RE: DRAINAGE PLAN FOR AN ADDITION TO CALVARY TEMPLE (E11-D25)  
ENGINEER'S STAMP DATED 12/4/98

RE: CONCEPTUAL DRAINAGE PLAN FOR AN ADDITION TO CALVARY TEMPLE  
( E11-D25) ENGINEER'S STAMP DATED 5/10/97

RE: DRAINAGE PLAN FOR CALVARY TEMPLE, (E11/D25)  
ENGINEER'S STAMP DATED FEBRUARY 14, 1990

CONCEPTUAL GRADING & DRAINAGE PLAN

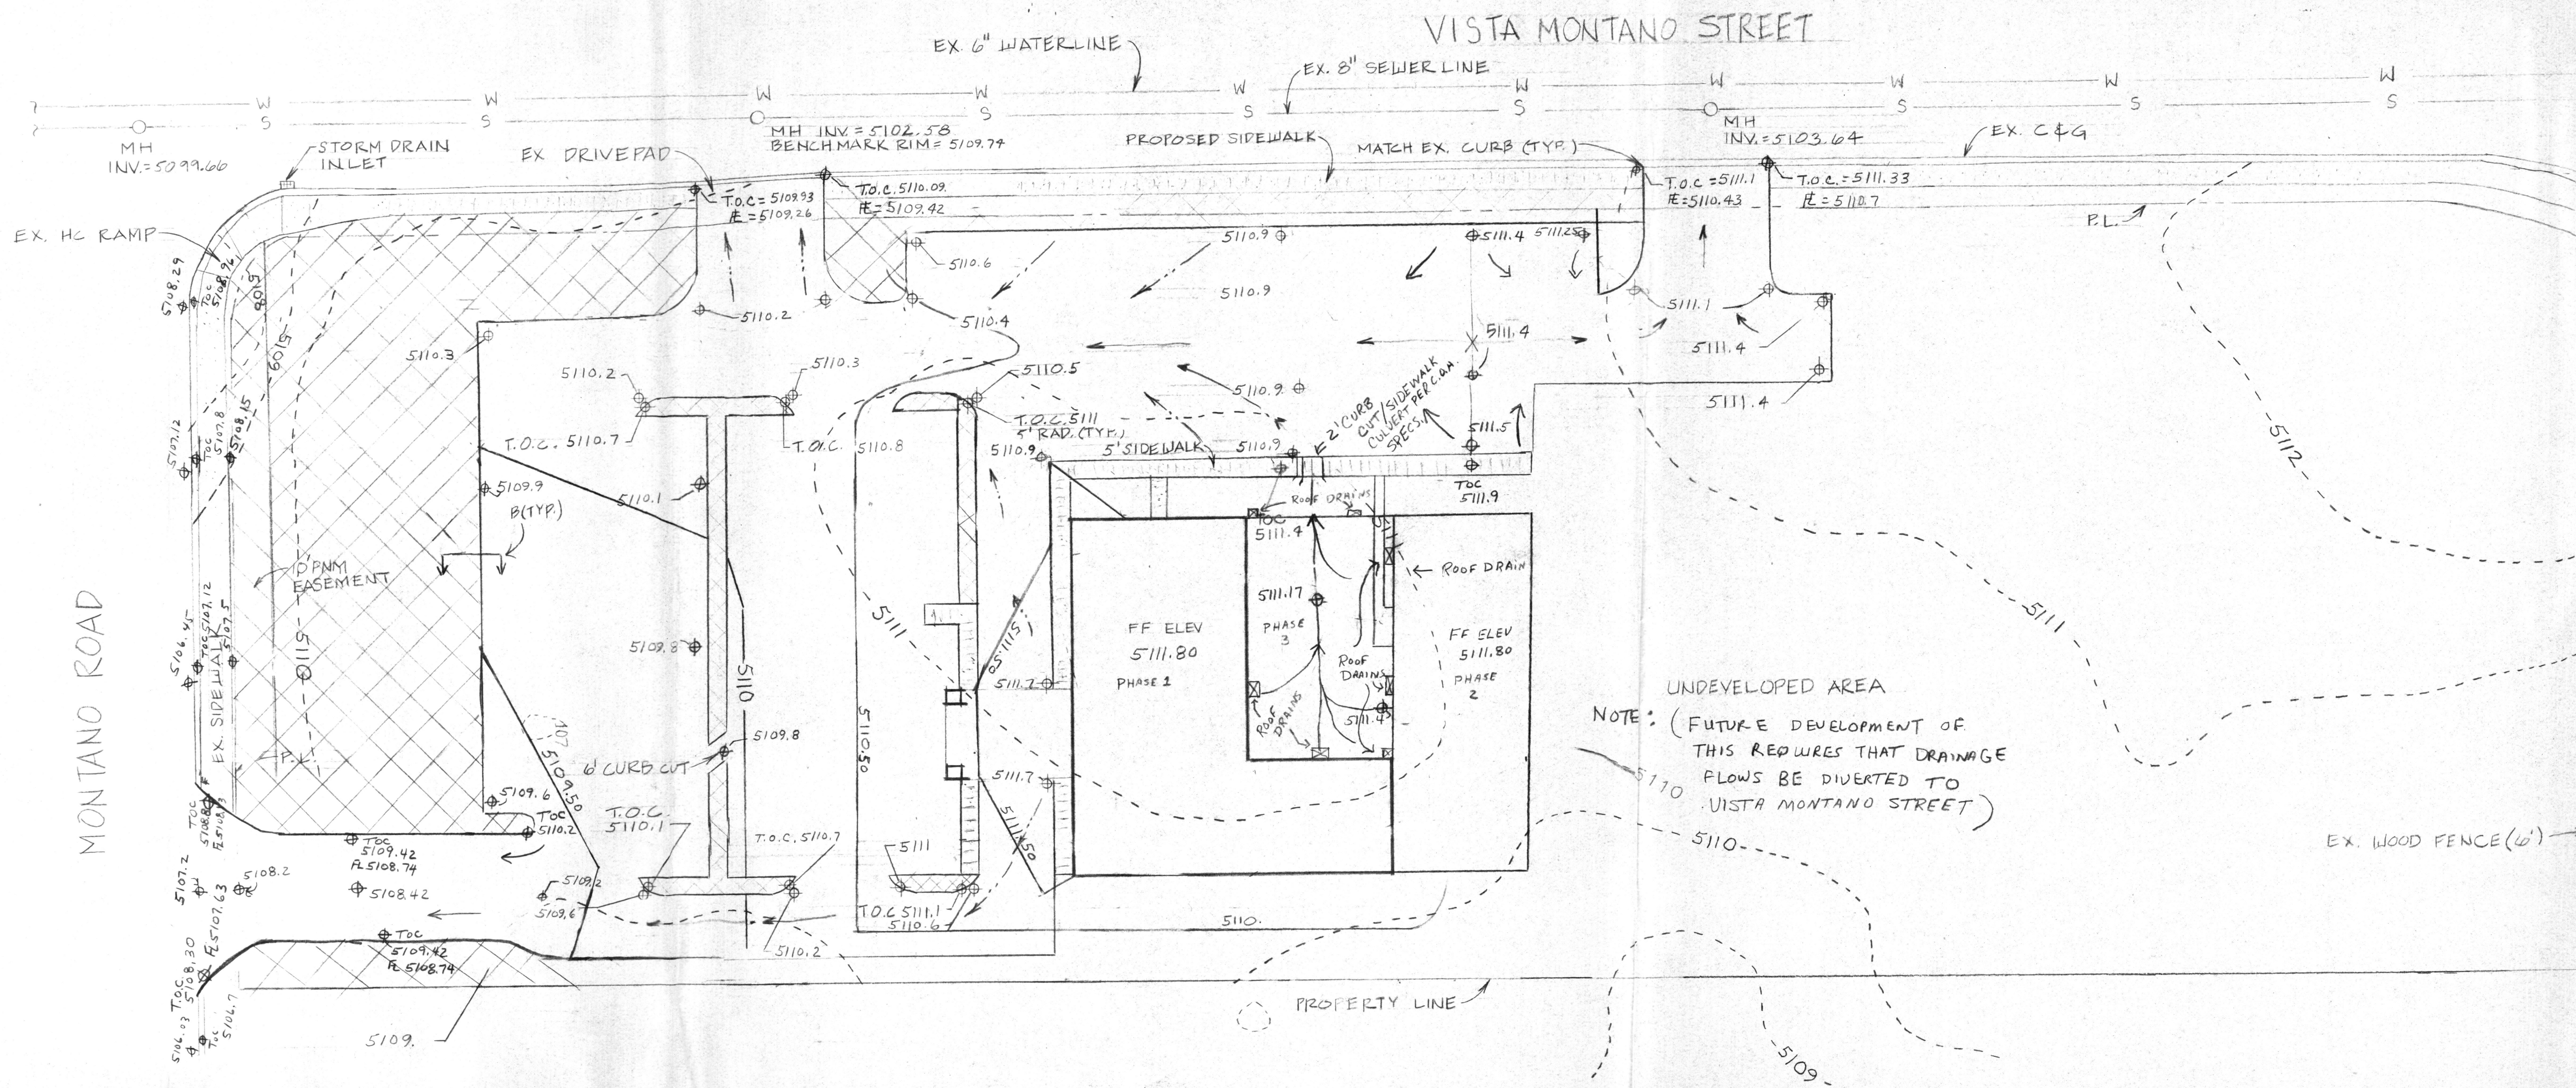
1. Type and size of the proposed openings to allow the run-off to exit down towards the street.  
( at the northeast corner of the existing building and from the proposed southern parking lot)
2. More spot elevations within the parking areas and the slope of the proposed swales.
3. Top of curve elevations on the proposed header curb.
4. Recommend that the roof drains be routed under the proposed sidewalks.

TITLE
CALVARY TEMPLE ASSEMBLY OF GOD
5951 MONTANO RD NW, ALBUQUERQUE, NM.
DRAINAGE/GRADING PLAN JAN. 15, 1990

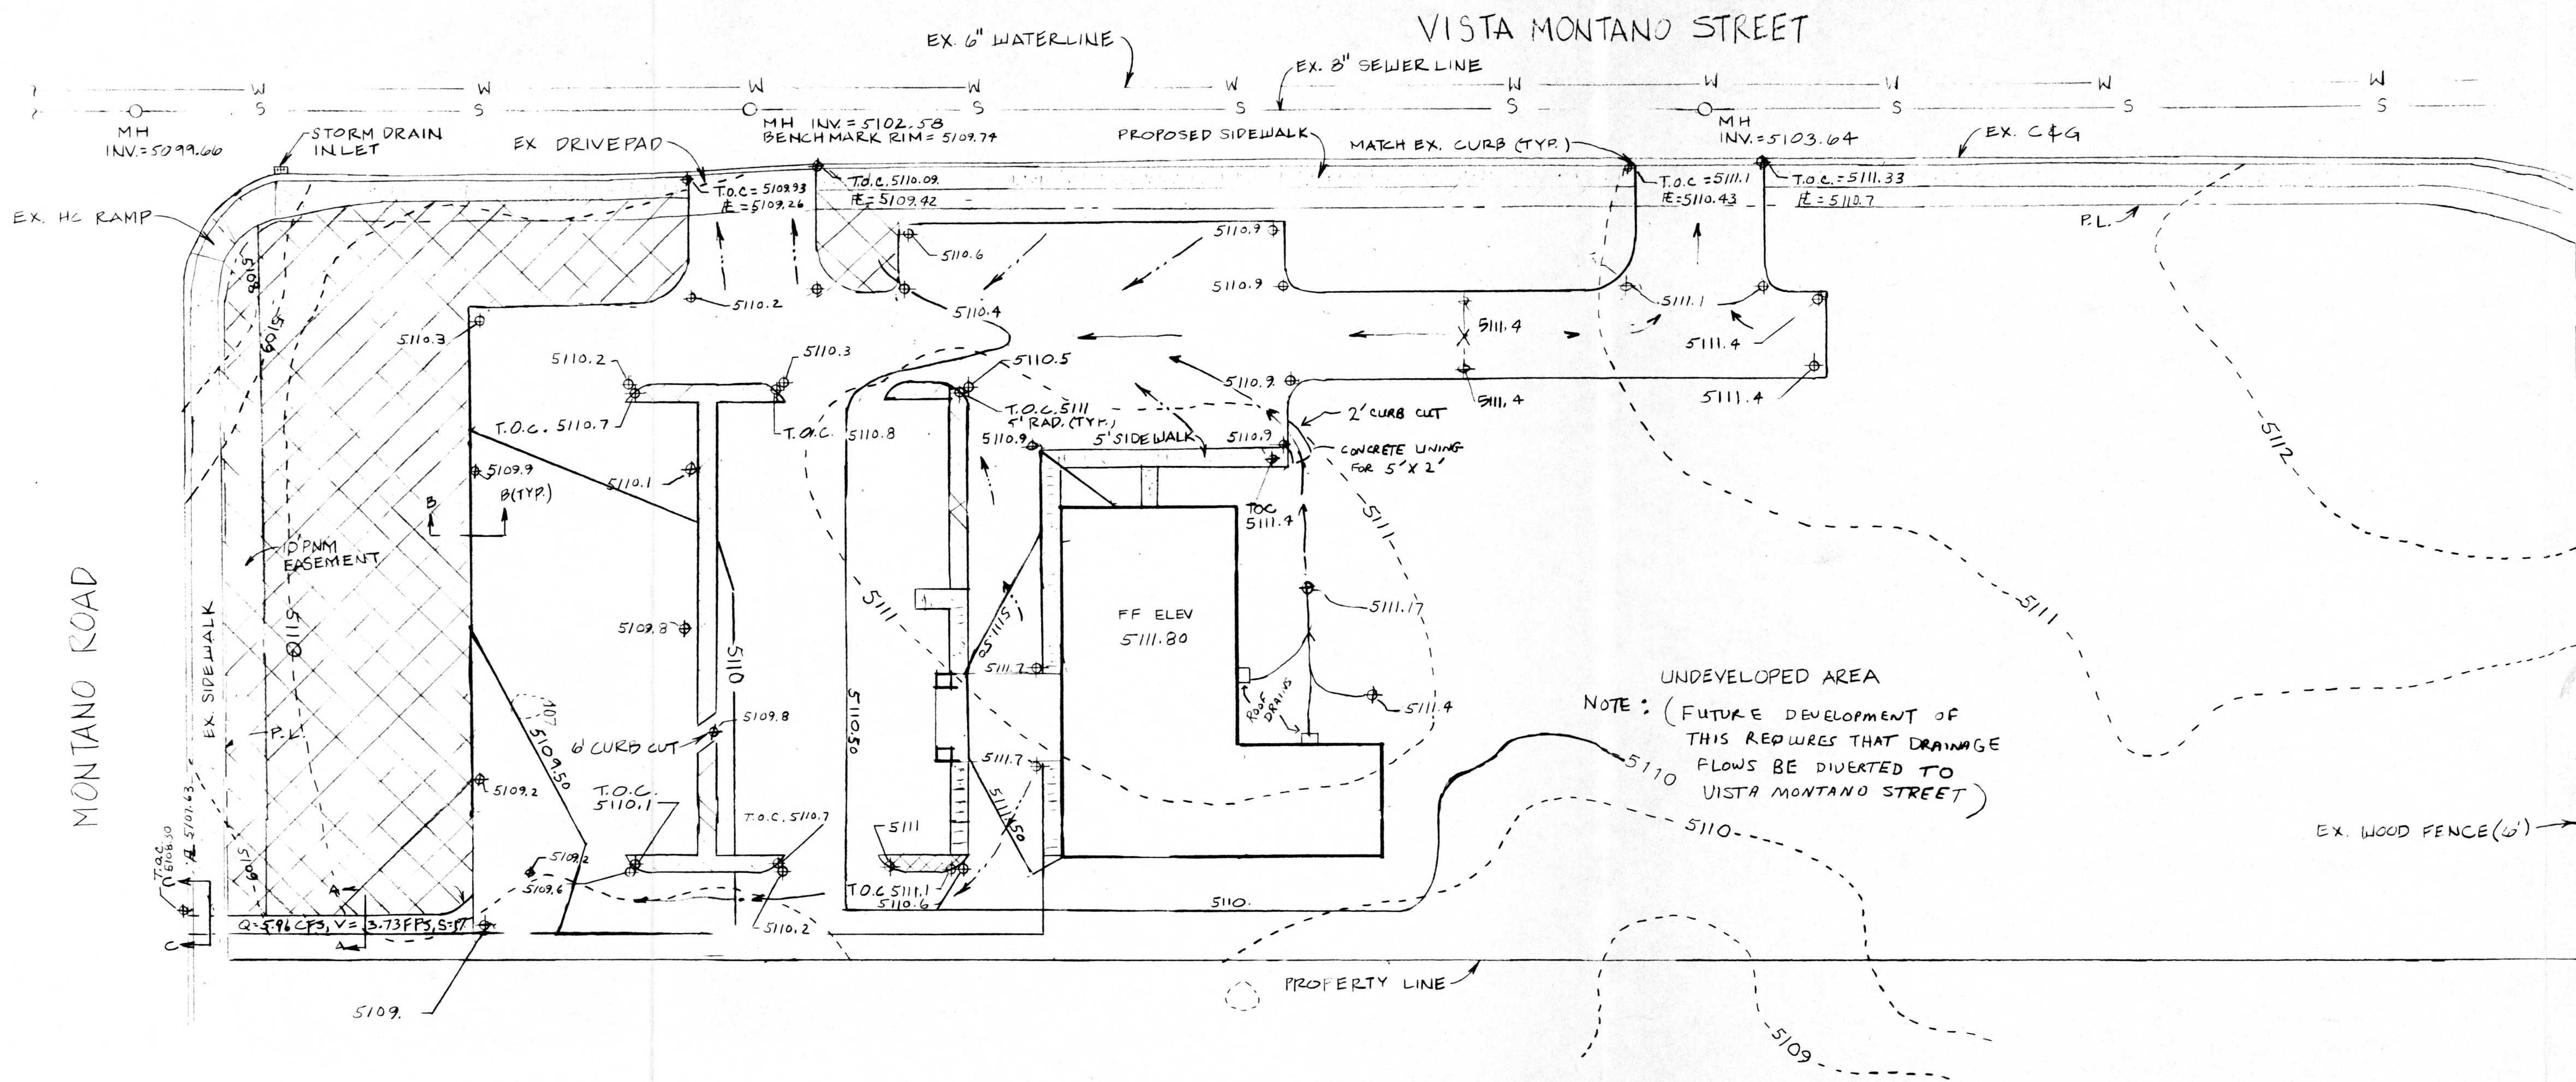
As I pointed out to you before on previous letters, all work performed within the City right-of-way must be per the City of Albuquerque Standard Specifications for Public Works Construction. In particular, Section C-C for the sidewalk culvert as identified in your plan is not allowed. This culvert must be constructed per Drawing 2236, of the above mentioned specifications.
